Application No: R/89/21/HH
Site Address: 74 The Martlets Rustington BN16 2UE
Description of works: Erection of a timber single storey granny annexe for ancillary use to the main dwelling.

Thank you for your internet representation made on 26th May 2021 which has been recorded as an objection with the comments as follows:

BLOCK PLAN

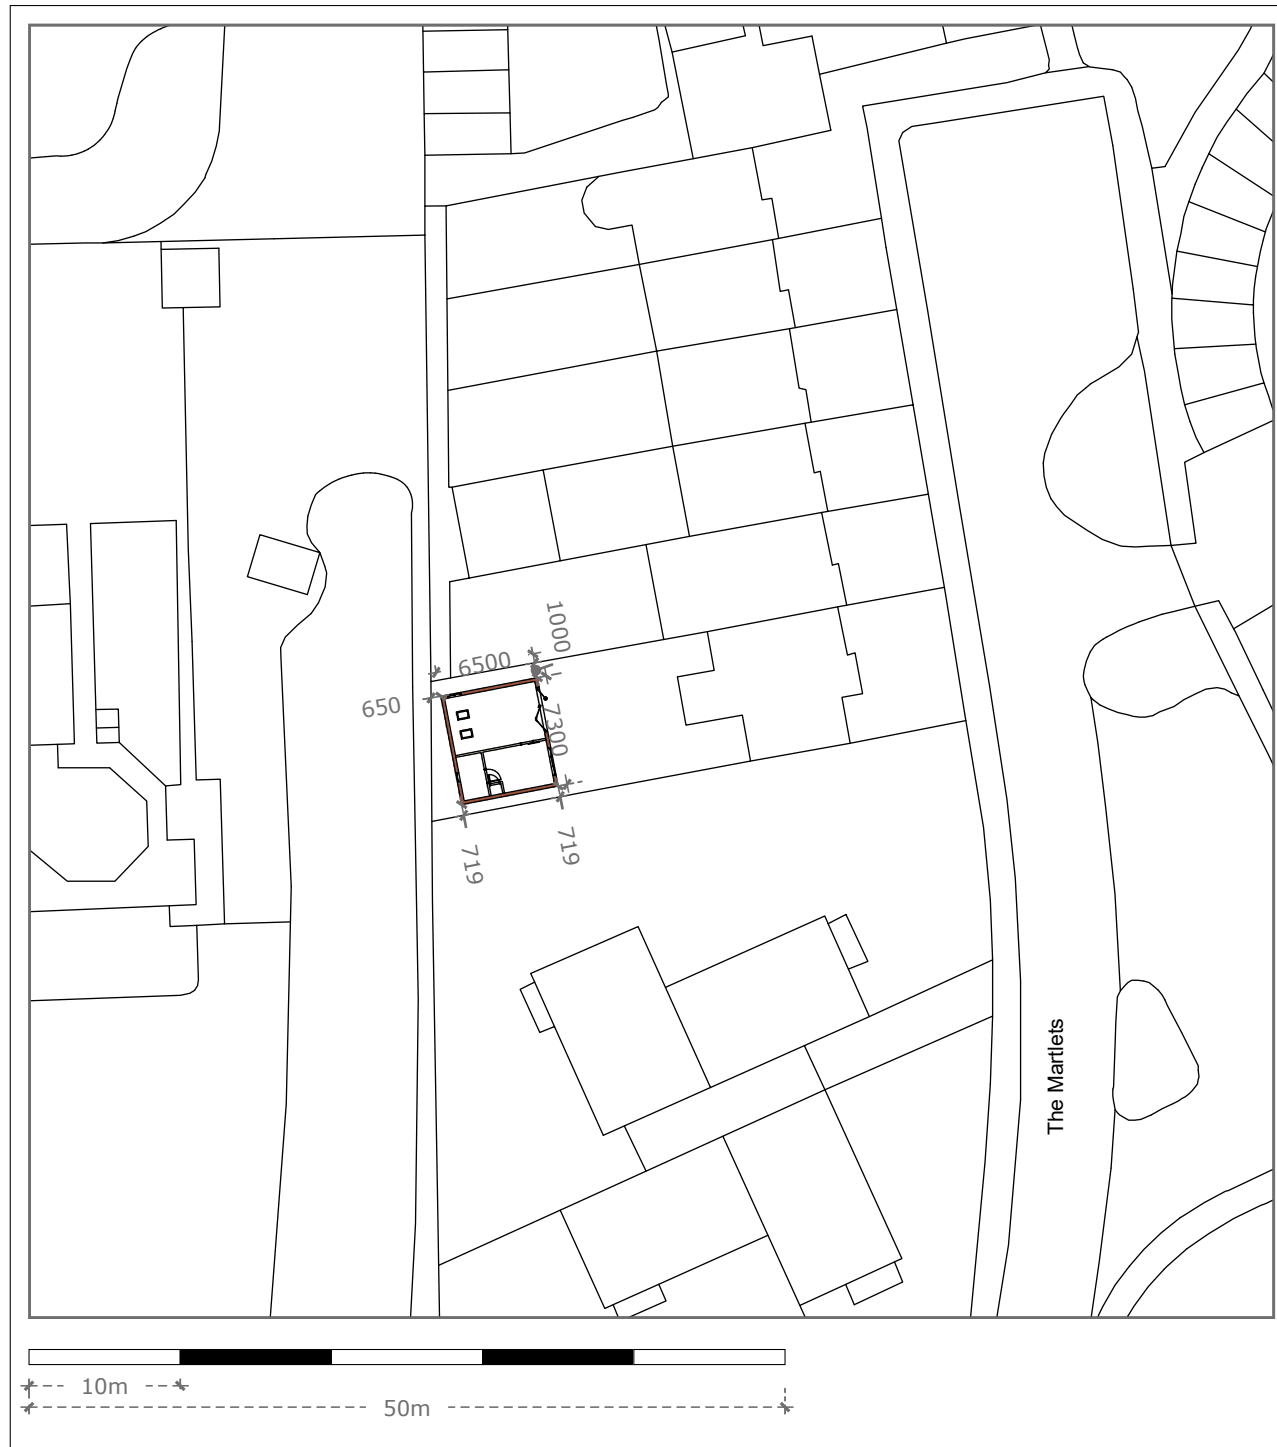
- (i) The proposal for a timber single storey annexe, of some 7.3 metres in width and 6.5 metres in length, with the side wall being over half the length of the neighbouring property's garden, would most certainly represent an overbearing impact for the said property, namely No. 72 The Martlets
- (ii) The proposal would have an adverse effect on the privacy, visual amenities and quiet enjoyment of the occupier/s of the aforementioned neighbouring property
- (iii) The proposal, by reason of its mass, would represent an over-development of the site
- (iv) The proposal would be in conflict with Policy 2 of the Rustington Neighbourhood Plan (mass and overbearing impact).
